9 February 2021

STATE SIGNIFICANT DEVELOPMENT APPLICATION (SSD8660), KARIONG SAND & SOIL SUPPLIES FACILITY, LOT: 4 DP: 227279 NO. 90 GINDURRA ROAD SOMERSBY

Thank you for the opportunity to provide comment on the Supplementary Response to Submissions for the above proposal. The following comments are made, and should be read in conjunction with Councils previous comments dated 24 September 2020.

PROJECT: PROPOSED KARIONG SAND & SOIL SUPPLIES FACILITY - SSD8660
GENERAL ARRANGEMENT PLAN

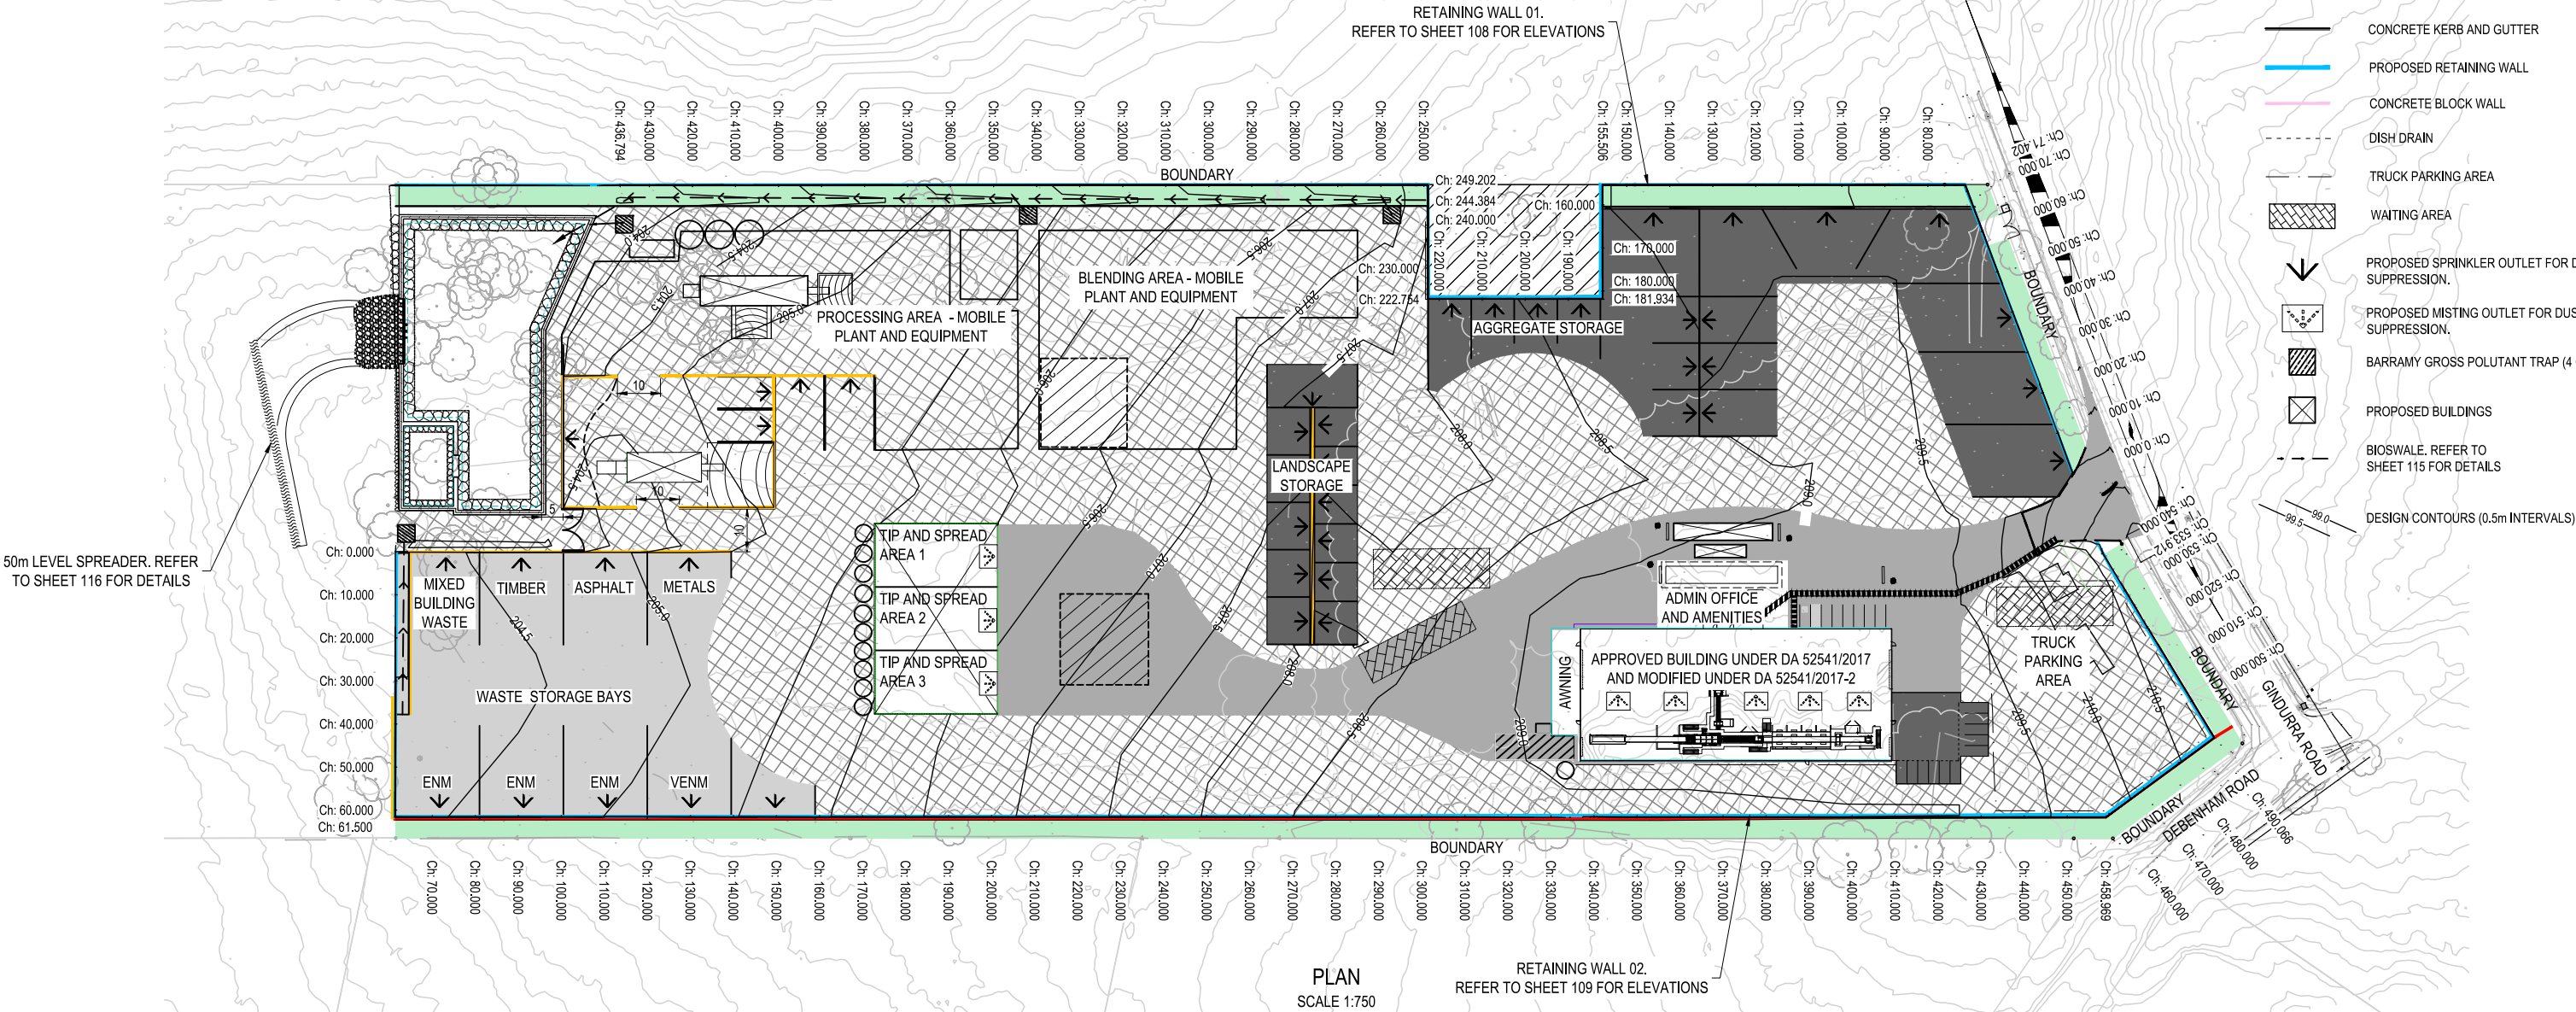
The additional Technical Design Note prepared by Seca Solution Pty Ltd dated 10 December 2020 is noted. The revised proposal to recess the access driveway gate 26m within the front boundary to Gindurra Road to allow a 26m B-double vehicle to wait on the site without impacting traffic along Gindurra Rd is supported.

As per previous comments, the proposed concrete median in the footway is not supported as it creates a hazard for pedestrians in the footway. This is a public footway and pedestrians could still utilise this area whether there is a footpath or not.

- b. The entry gate shall be located within the property a minimum of **26m** away from the front boundary to permit **Austrroads 26m B-Double Vehicles to enter without obstructing Gindurra Road footway area.**

- b. The entry gate shall be located within the property a minimum of **26m** away from the front boundary to permit **Austrroads 26m B-Double Vehicles to enter without obstructing Gindurra Road footway area.**

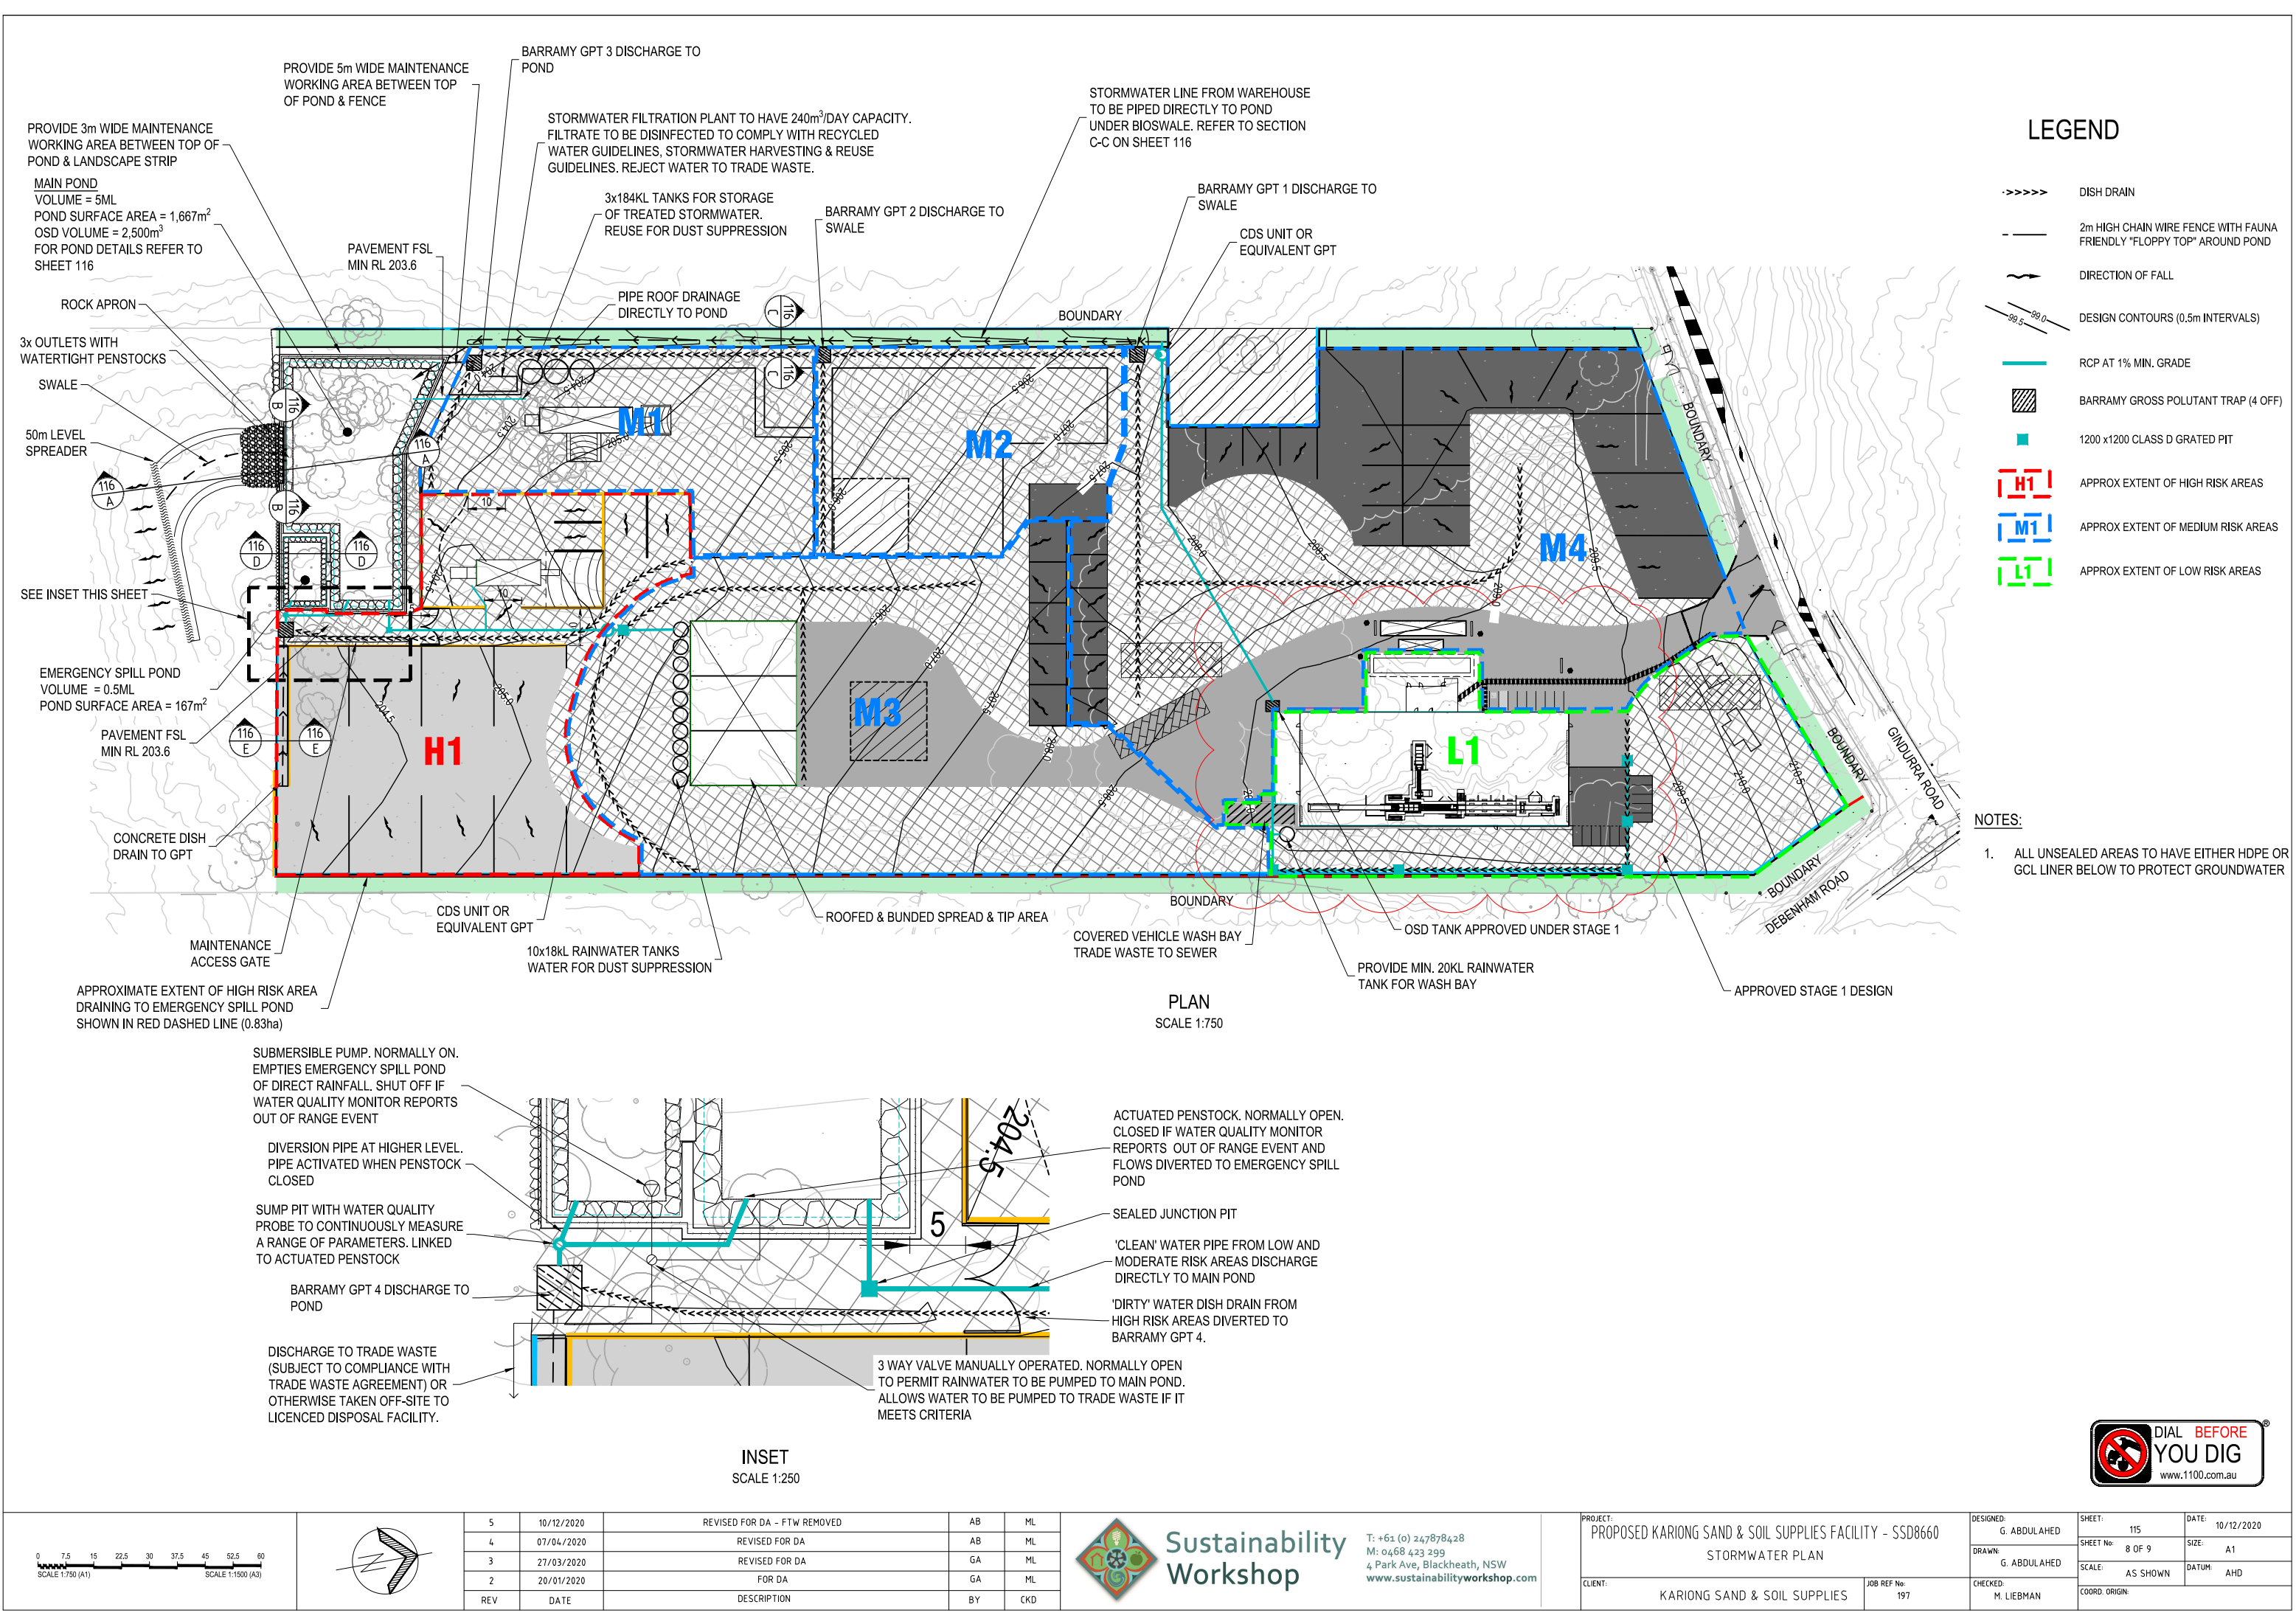
Changes have been made to the OSD basin so it will be operated with a 5-day trigger to discharge, meaning it will discharge treated water to the environment under controlled conditions once water quality criteria have been achieved to reduce the frequency of predicted uncontrolled discharges. No objections are made to this proposal.

- f. Piping of all stormwater from impervious areas generally in accordance with the Water Cycle Impact Assessment and Soil and Water Management Plan prepared by Sustainability Workshop (Ref Project No 197 Issue H dated 23 June 2020) **and the Water Cycle Impact Assessment and Soil and Water Management Plan prepared by Sustainability Workshop (Ref Project No 197 Issue C dated 7/12/20).**

- f. Piping of all stormwater from impervious areas generally in accordance with the Water Cycle Impact Assessment and Soil and Water Management Plan prepared by Sustainability Workshop (Ref Project No 197 Issue H dated 23 June 2020) **and the Water Cycle Impact Assessment and Soil and Water Management Plan prepared by Sustainability Workshop (Ref Project No 197 Issue C dated 7/12/20)**.
